Appeal Decision

Appeal Ref: APP/R5510/W/24/3342376

59 St Mary's Road, Hayes UB3 2JP

- The appeal is made under section 78 of the Town and Country Planning Act 1990 against a refusal to grant planning permission.
- The appeal is made by Mr H Singh against the decision of the Council of the London Borough of Hillingdon
- The application is Ref. 42412/APP/2024/70.
- The development proposed is a 2 bedroom dwelling to the side of the existing property.

SITE LOCATION PLAN

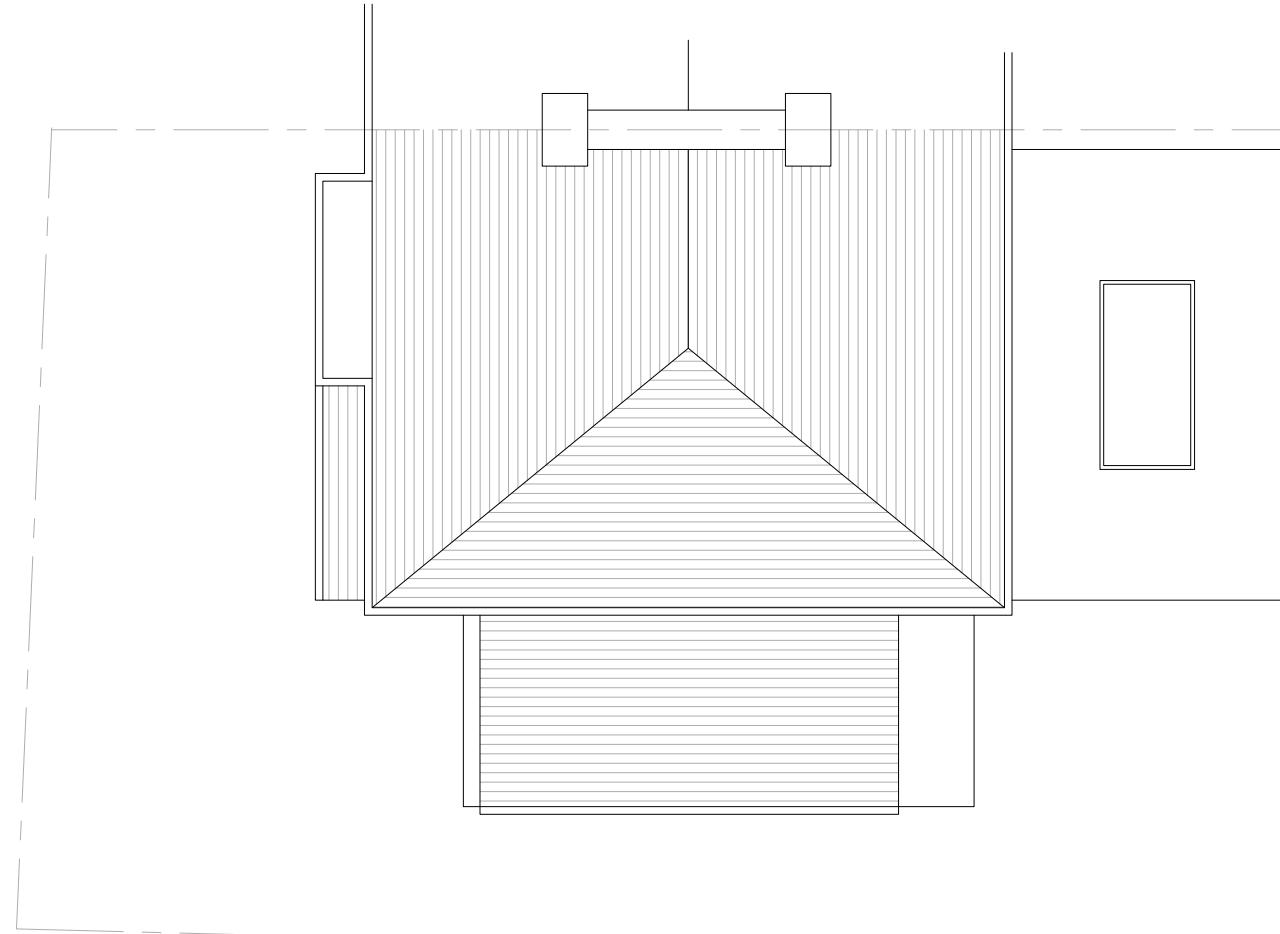
4. No. 59 is an end of terrace dwelling and the last house on the southern side of St Mary's Road on the approach to the junction with Church Road, a short distance to the west. The land between No. 59 and this junction is the site of Hayes Town Chapel. And from both the submitted OS-based Site Location Plan and my own observations, it is apparent that apart from a slight widening at the front there is only a minimal gap between the plot boundary of No. 59 and the flank wall of the chapel building.

Drawing name:
Proposed Elevations

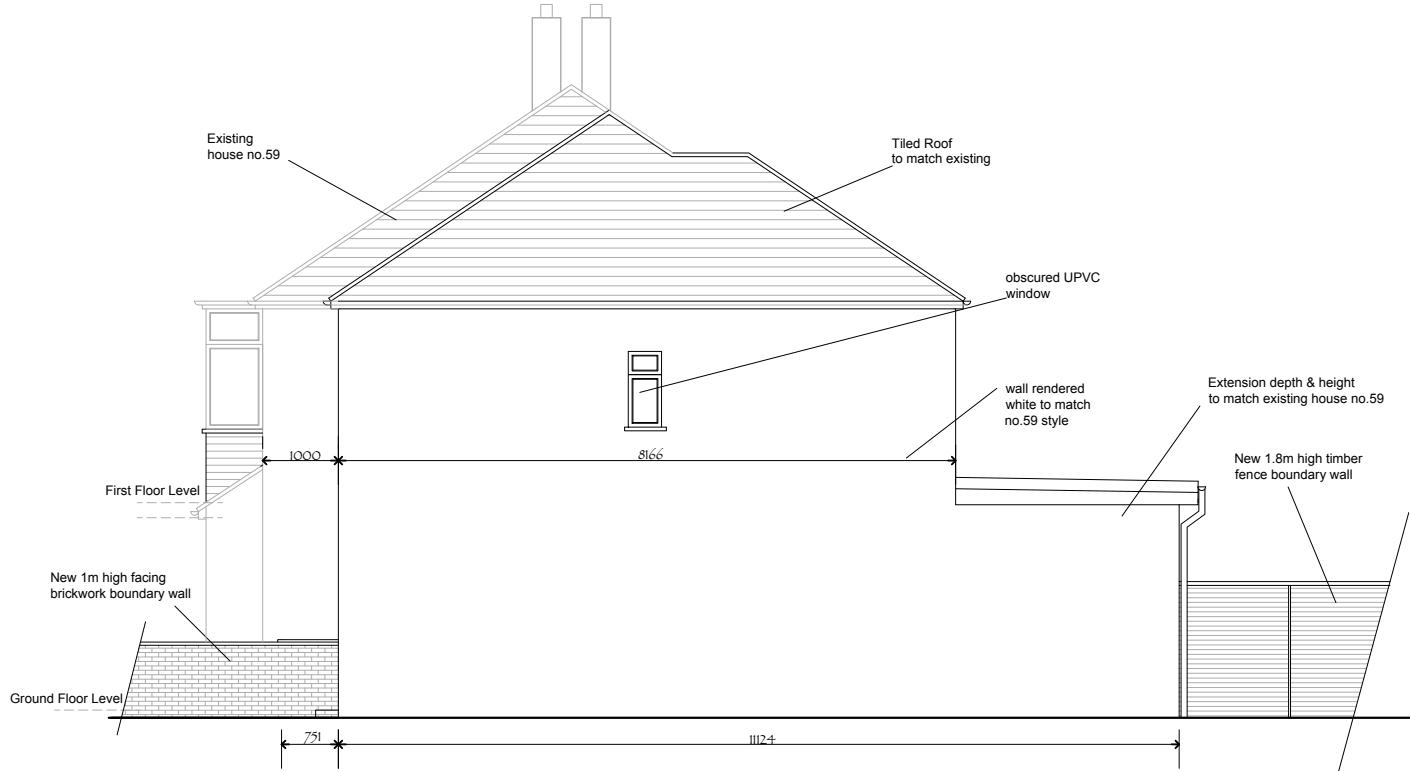
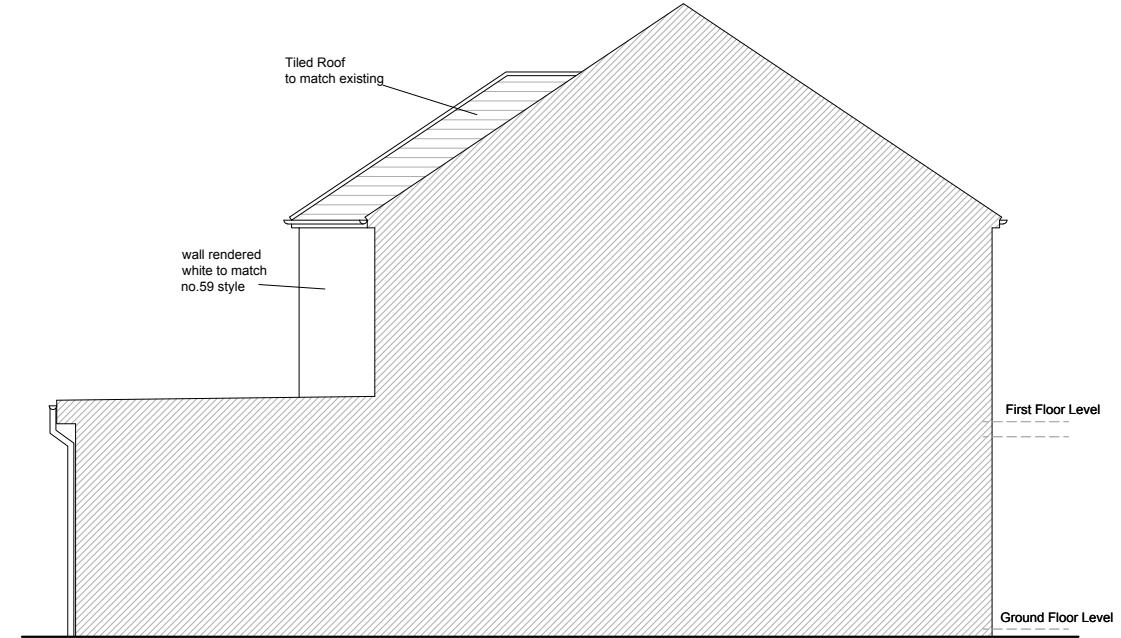
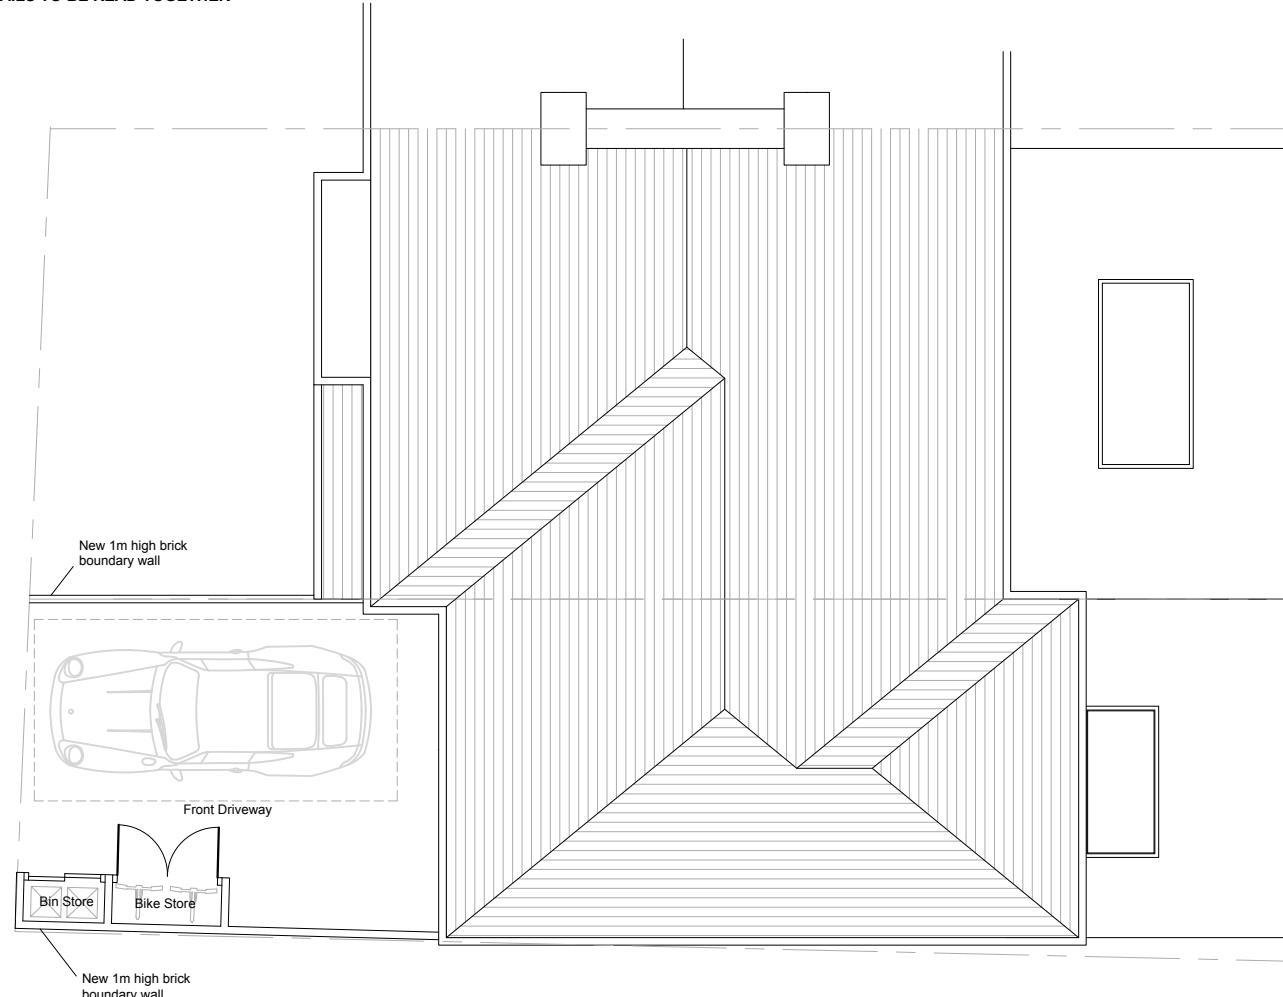
This would be set back from the front by a similar distance to the existing garage and set down from the existing roof line of the house. Unlike the existing attachment, the proposed dwelling would be built on the actual boundary with the Chapel site to achieve the necessary width.

7. From close examination of the submitted drawings, I consider that the width achieved by building on the site boundary would not result in the building as appearing incongruously narrow, either in itself or in relation to No. 59. This is because it would essentially read as a two-storey extension to the house with the conventional set-back and set-down to achieve the required subordination, whilst the fenestration would be entirely in keeping with the host dwelling.

8. The exception to this is the front door, which does introduce an element of incongruity. With that said, this incompatibility would be perceived more by relevant professionals (architects/ planners/surveyors) than the average passer-by who would be unlikely to give it a second glance. The further argument in favour of the width being acceptable is that internally the floorspace would provide conventional room sizes at both ground and first floor levels and overall, more than the requisite floorspace to meet the Nationally Described Space Standard.

10. Taking the above observations into account, I consider there are two main features of the development that make the development acceptable. Firstly, the proposed front elevation being set back by a metre would preclude any necessity for it to blend with the existing frontage, with the front door an insignificant feature in relation to the terrace as a whole. Secondly, although the Chapel is very close to the site boundary, a perception of the new dwelling being cramped would be alleviated through the combination of this set-back with the adjoining flank of the Chapel being only single storey and having a shallow pitched roof. The overall outcome would be that the proposal would not be so 'squeezed in' as to draw the eye as being unduly cramped and contrived.

- 5) The first floor side window facing Hayes Town Chapel shall be glazed with permanently obscured glass to at least scale 4 on the Pilkington scale and be non-opening below a height of 1.8 metres taken from the internal finished floor level and thereafter retained in that form;

- 6) Access to the flat roof over the extension hereby approved shall be for maintenance or emergency purposes only and the flat roof shall not be used as a roof garden, terrace, balcony, patio or similar amenity area;

Proposed Site Plan (1:100)

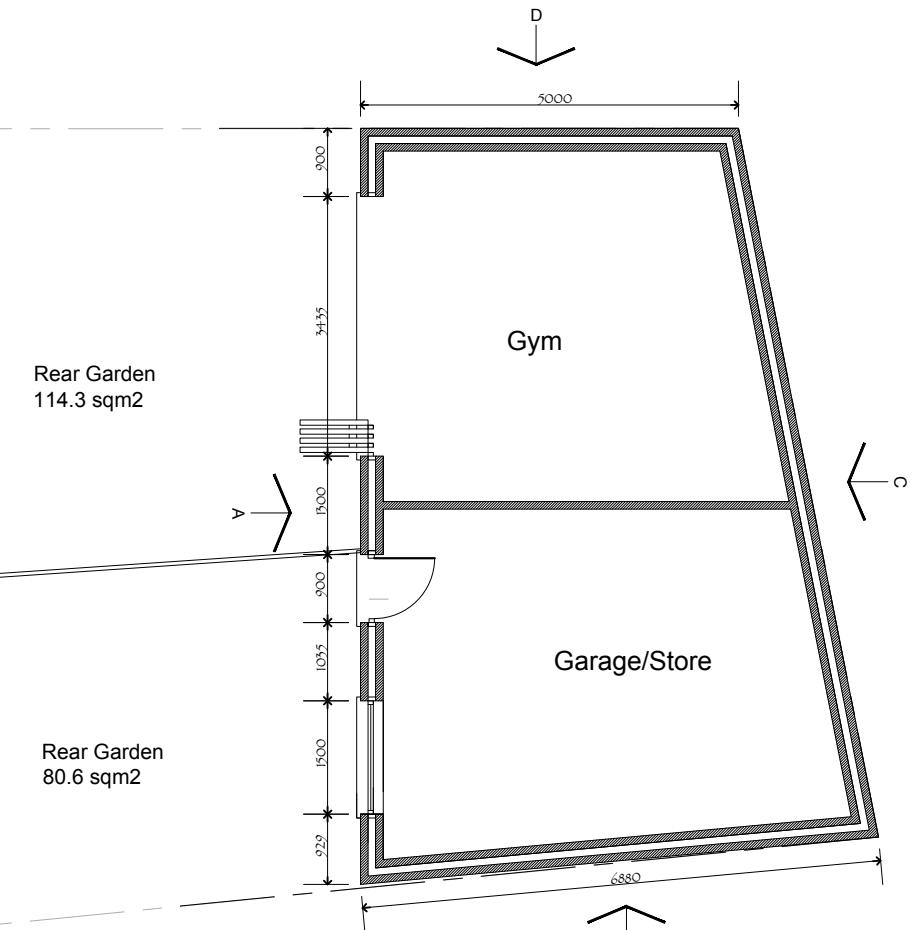
15. The suggested condition that I consider to be unnecessary is the detailed landscaping condition. This is because the amenity space to be provided is in the form of an enclosed rear garden that would not be seen from the public realm. I have replaced this with an essentially similar but more limited condition requiring the submission and approval of details of the area to be retained in front of the dwelling, including the parking space and storage facilities.

- 11) The dwelling shall not be occupied until the hard surfacing for the parking space and adjacent land at the front of the dwelling; a 7Kw active EVCP; and the construction of the bin and cycle stores have been constructed /installed in accordance with details first submitted to and agreed in writing by the Local Planning Authority. Thereafter the parking space, charging point, bin and cycle stores will be retained in accordance with these details for as long as the development remains in existence;
